Review **Section 8.4.7 Water Supply Standards** of the Land Development Code

OWL MARKETPLACE

WATER RESOURCES REPORT

October 2023

# OWL MARKETPLACE FILING NO. 1

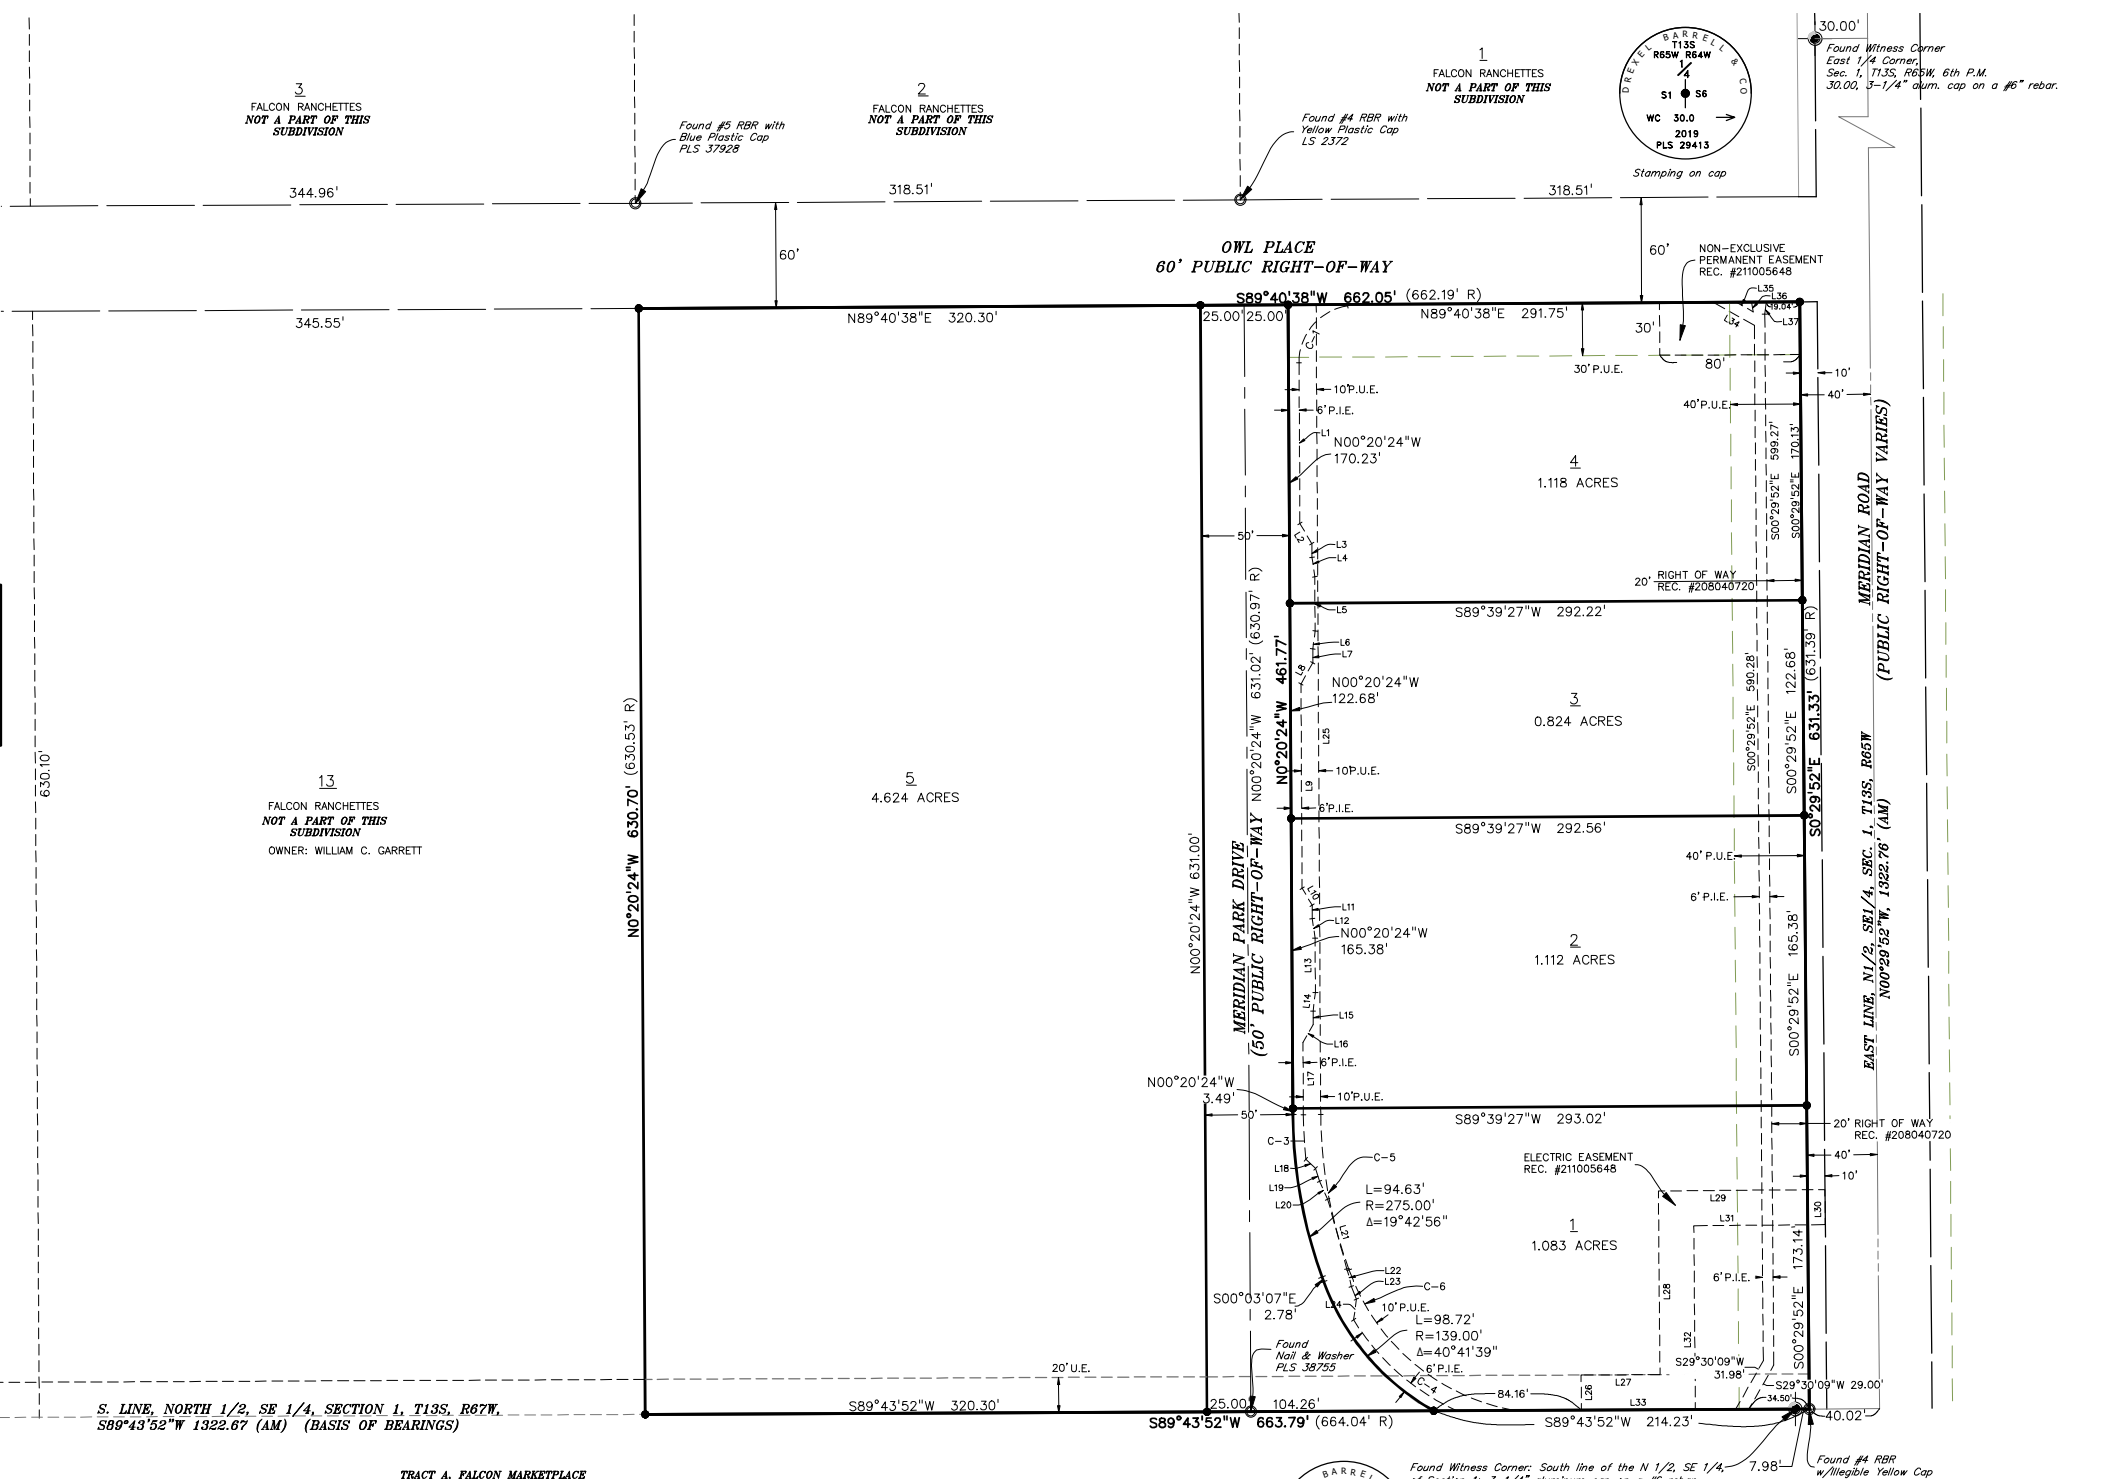
**REPLACE
PLAT**
